The Hills Shire Council Engineering Comments:

SSD 83112728 – Carrington, Fishburn and Sexton Ave

Figure A 4.1 OSD Catchment Plan

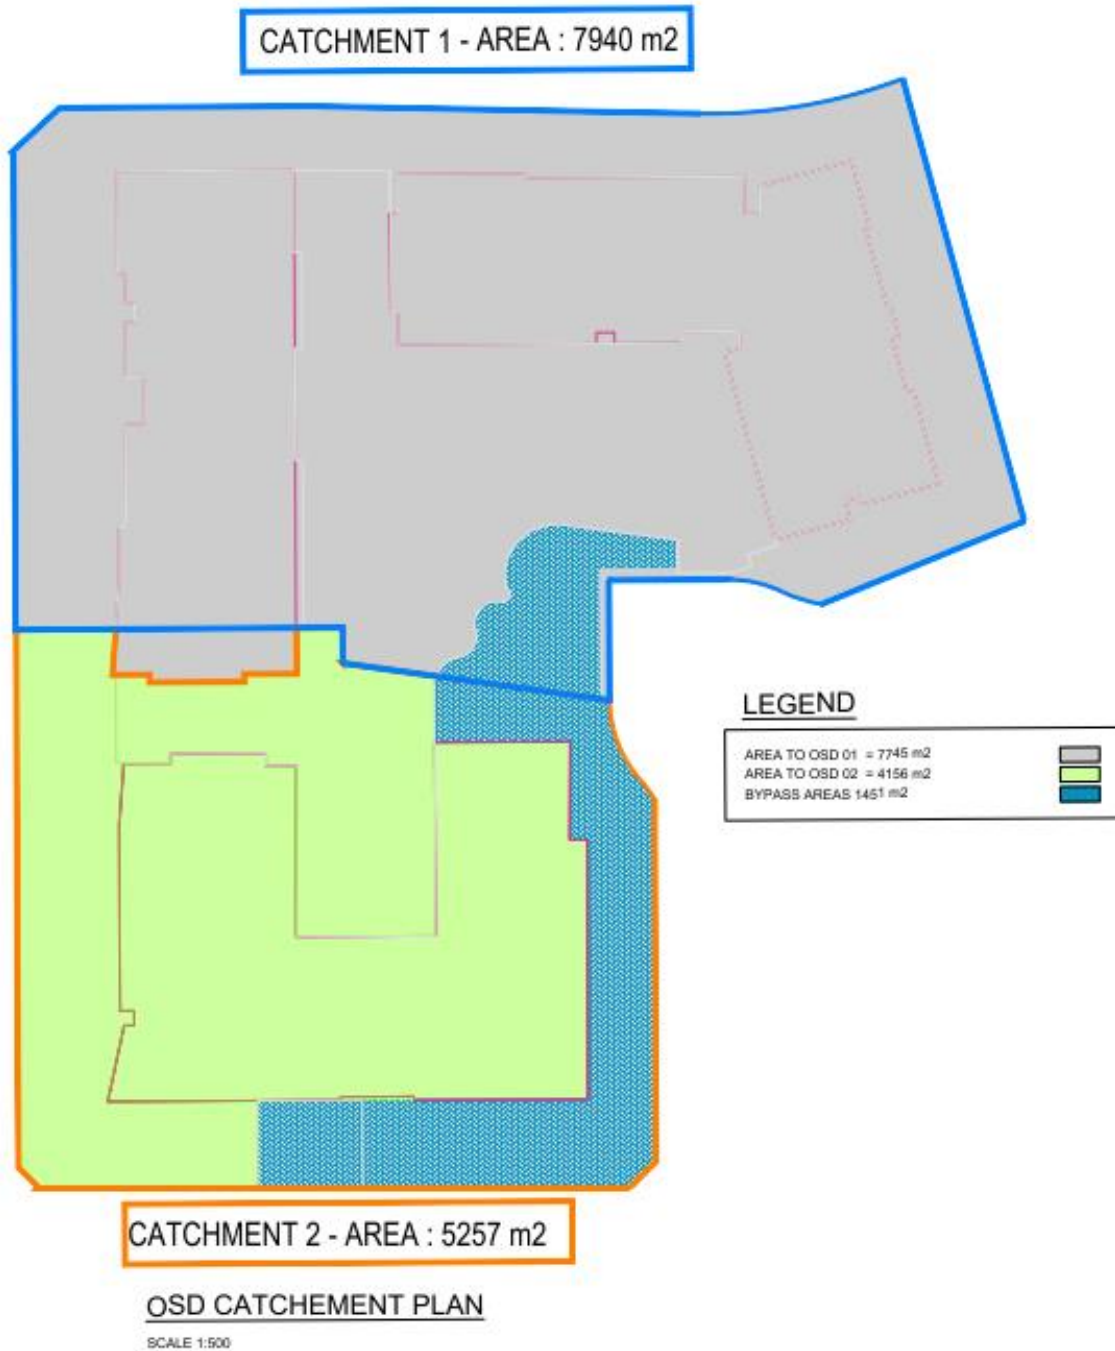
17. The Stormwater Concept Design drawings and associated report propose two OSD sub-catchments controlled by two OSD tanks. The OSD tank 1 has two separate chambers linked to achieve the required volume. However, the design integration of the two chambers named Volume 1 and Volume 2 have not been demonstrated with adequate design details including pipe sizes connecting the tanks, levels etc. Amended design documents must detail hydraulic integration of the two chambers.

18. Noting that some areas of the development bypass the OSD tanks. Therefore, the OSD design calculations must be amended using the actual sub-catchment areas as site areas and insert the bypass area at appropriate place to ensure the design calculations are true representations.
19. The Sub-Catchment 2 is proposed to be controlled by the OSD tank 02. However, the outlet pipe has been directed to a drainage pipe proposed across Middleton Avenue and Carrington Road intersection. As this catchment 02 does not belong to Carrington Road drainage network and the downstream drainage is not designed to accommodate this runoff, a separate kerb inlet pit and pipe extension must be provided to extend to the Patridge Avenue network.

Figure A 4.2 WSUD Catchment Plan

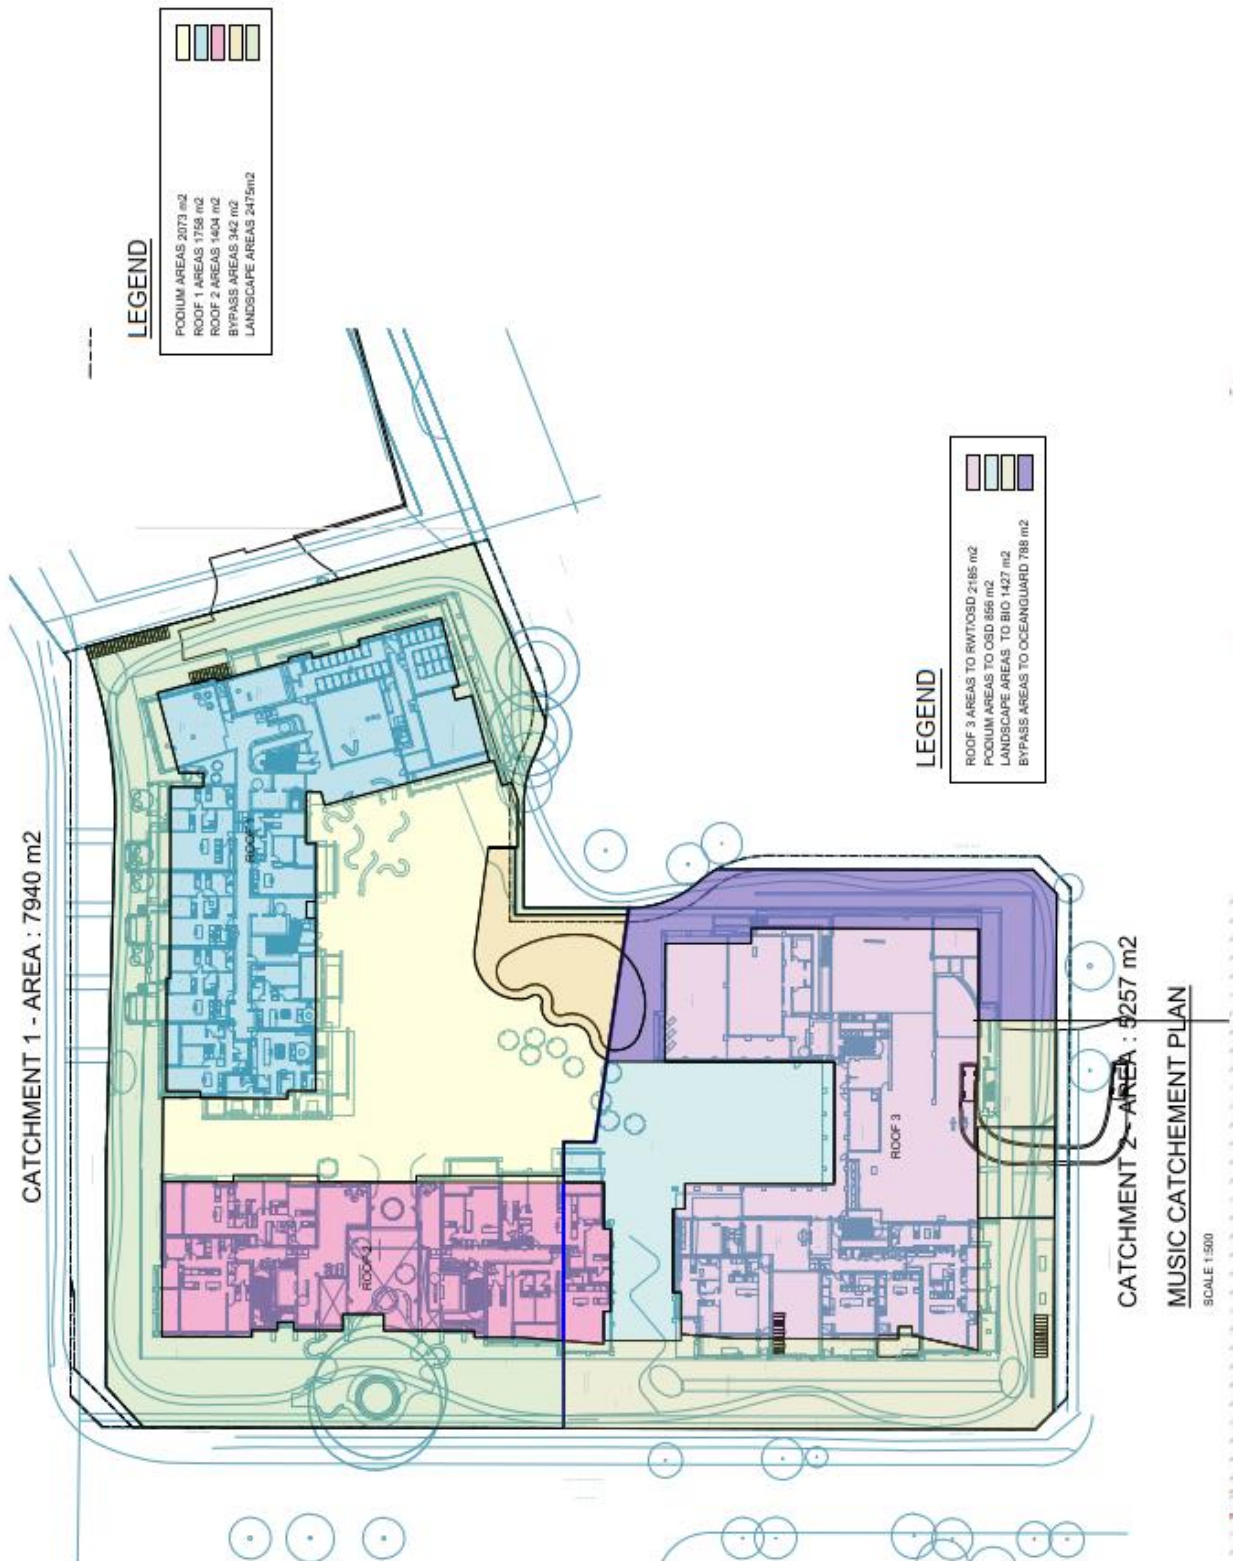
20. The development proposes Rainwater Tanks and Water Quality Treatment measures to ensure the quality of discharge water. Soft copy of MUSIC model accompanied by sub-catchments relate to MUSIC model are required for review.
